From: Jeff Tarling
To: Jean Fraser
CC: David Margolis-Pineo
Date: 9/3/2014 9:15 PM
Subject: Re: urgent- comments on 2282 Congress

In review of the recent updated site plan I offer the following review comments and conditions:

SHEET TITLE
LANDSCAPE PLAN

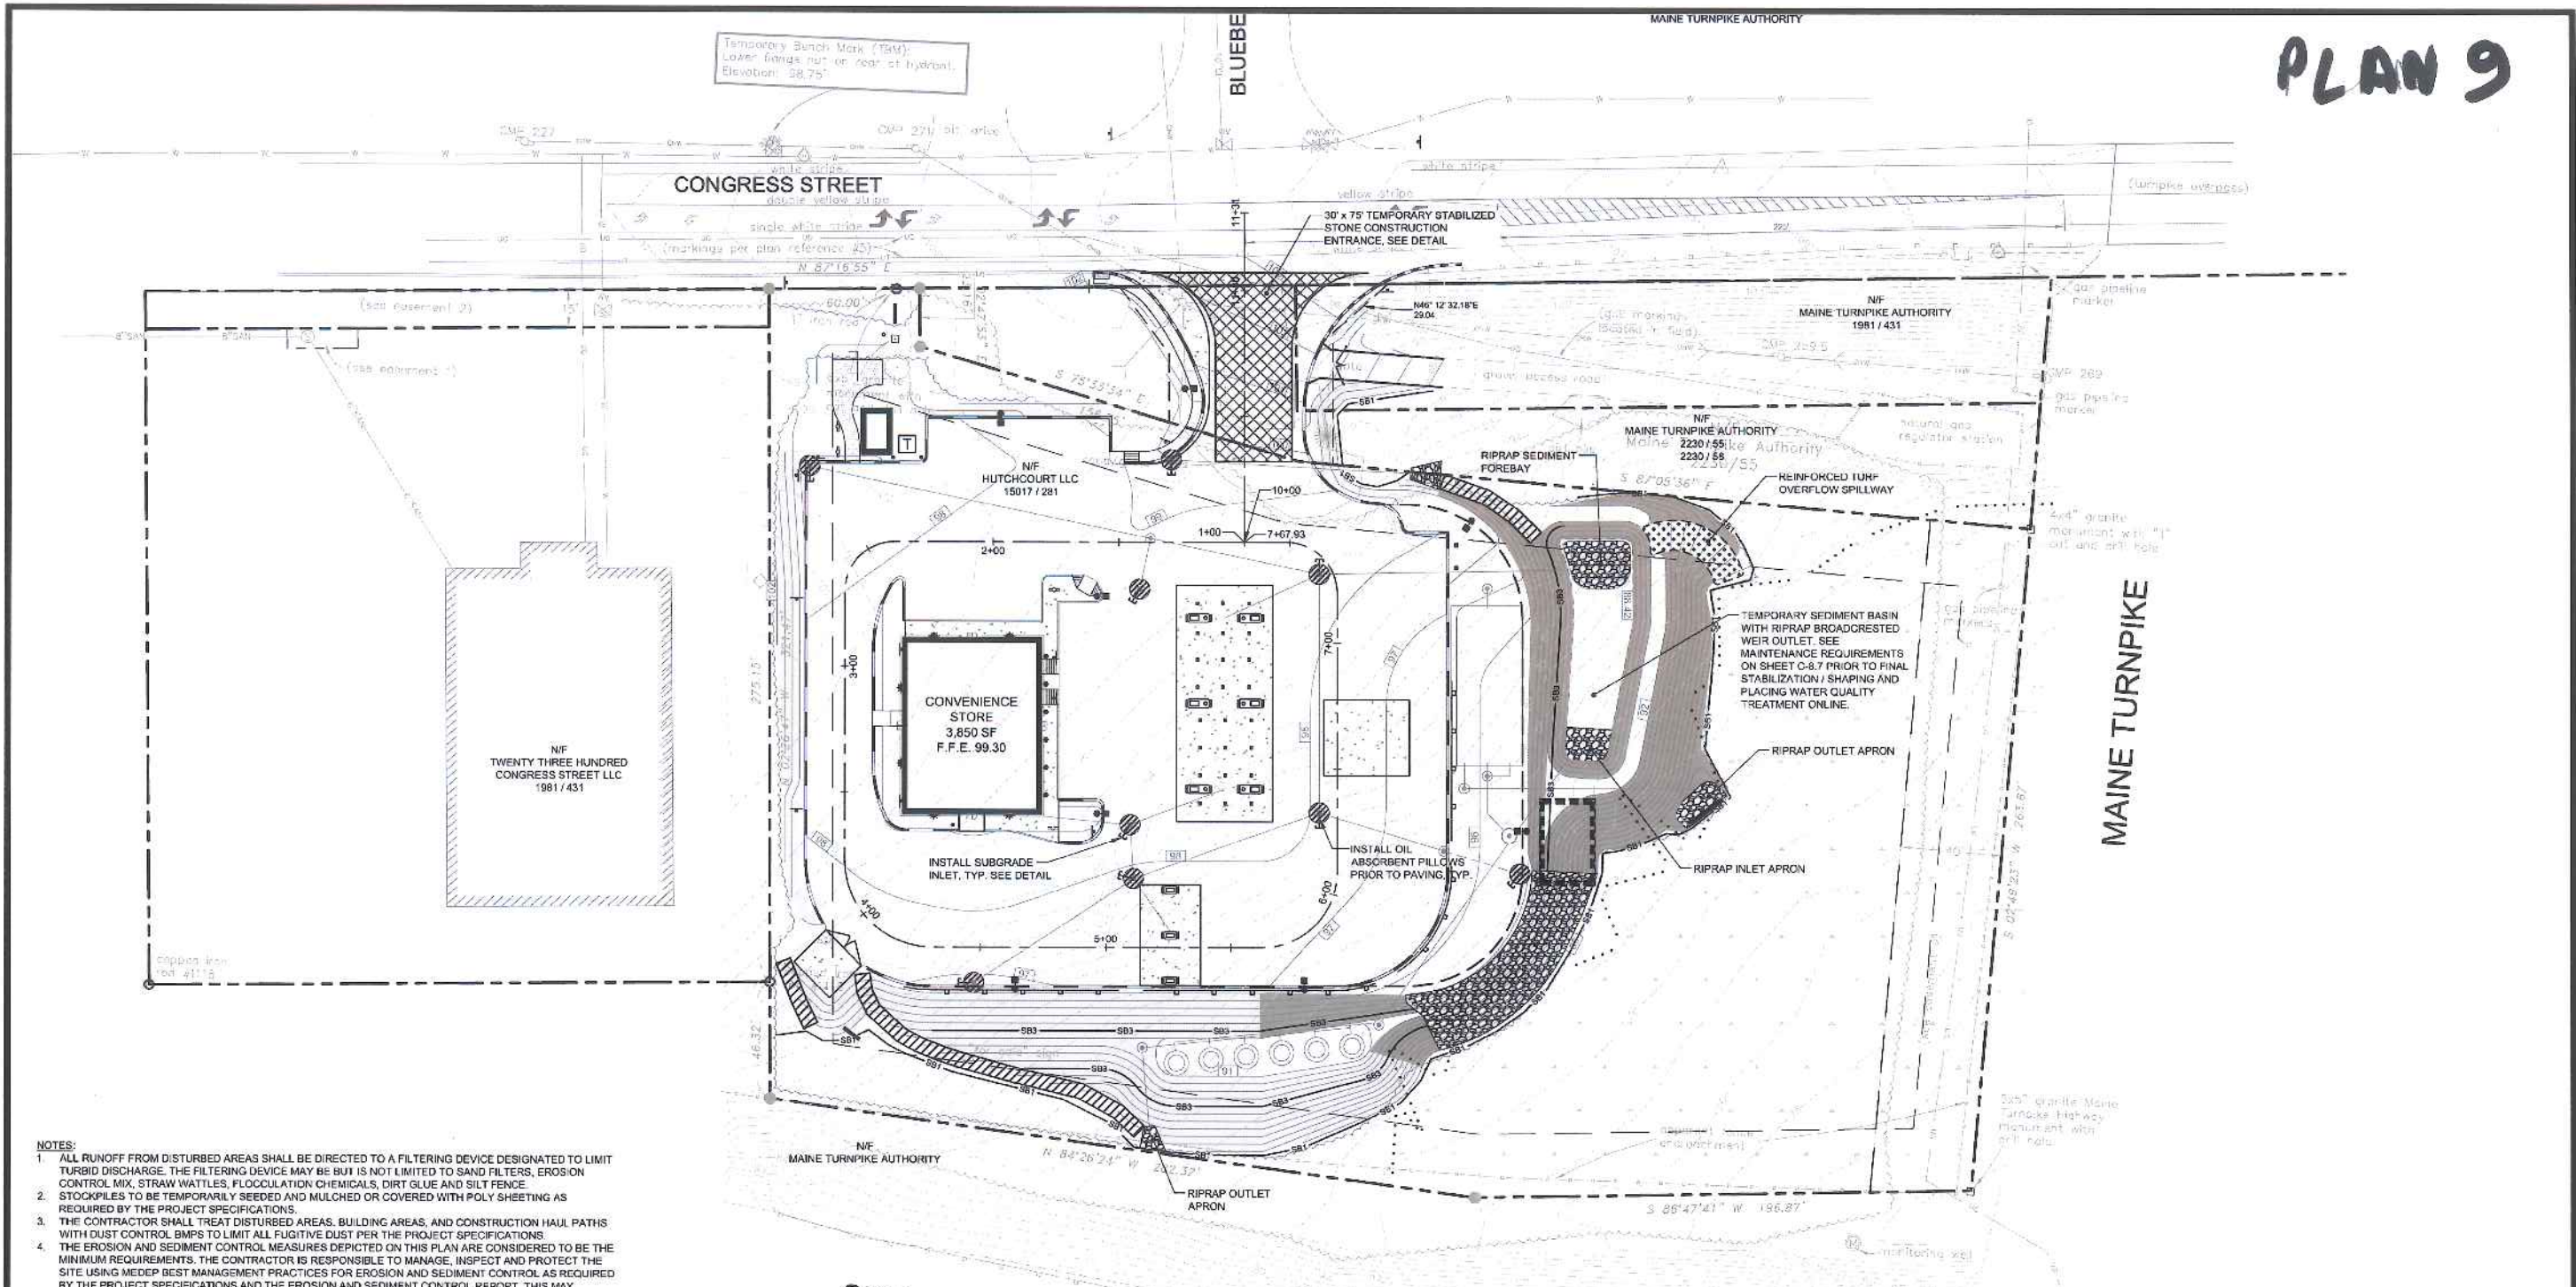
After revisiting the site and the extensive existing tree and landscape to be removed, I would recommend adjusting plant types and spacing so the site appears to mimic the existing and surrounding natural conditions. Native trees and shrubs are recommended using about the same number of plants as in the last approval. This is vital to protect the character of the gateway into Portland. One can note the surrounding landscapes including UNUM and the smaller commercial properties retain a large percentage of native trees. Conditions for approval should include:

a) Additional trees & landscape planting area - this is an extension of the original approval condition to add trees, shrubs to the area on the easterly side of the project near the edge of pavement and storm-water pond / drainage area.

Additional tree recommendations: five additional trees in this area - recommended types : Eastern Larch, a native deciduous conifer, 5-6' height or Black Tupelo 2" caliper or a mix of the two equaling five trees. The trees can be planted in groups or spaced to allow for snow storage.

Two groups of five shrubs should be planted along the westerly pond edge, these could be Winterberry, Bayberry, or Myrica gale.

b) Existing tree recommendations - Due to the site conditions the following tree types should be adjusted or changed:

1) White Pine - If the site conditions where the White Pine trees are proposed is wet - White Spruce would be recommended. Pin Oaks - the proposed Pin Oak should be changed to Swamp White Oak as a preferred native tree type for the conditions.

2) Blueberry shrub planting along pond edge - the goal here would be to try to make the site appear more natural. Thus arranging the plants in groups or clusters using the same number of plants as shown. Winterberry would be recommended as an alternative plant choice.

3) Arborvitae - following the theme to make the landscape near the drainage area appear more natural, alternative plant types using the same amount of tree units would be a condition. Instead of a straight row of Arborvitae, the planting of White Spruce, Larch, White Pine, or River Birch would be a recommendation. The spacing could be in groups or a wider 20 - 25'.
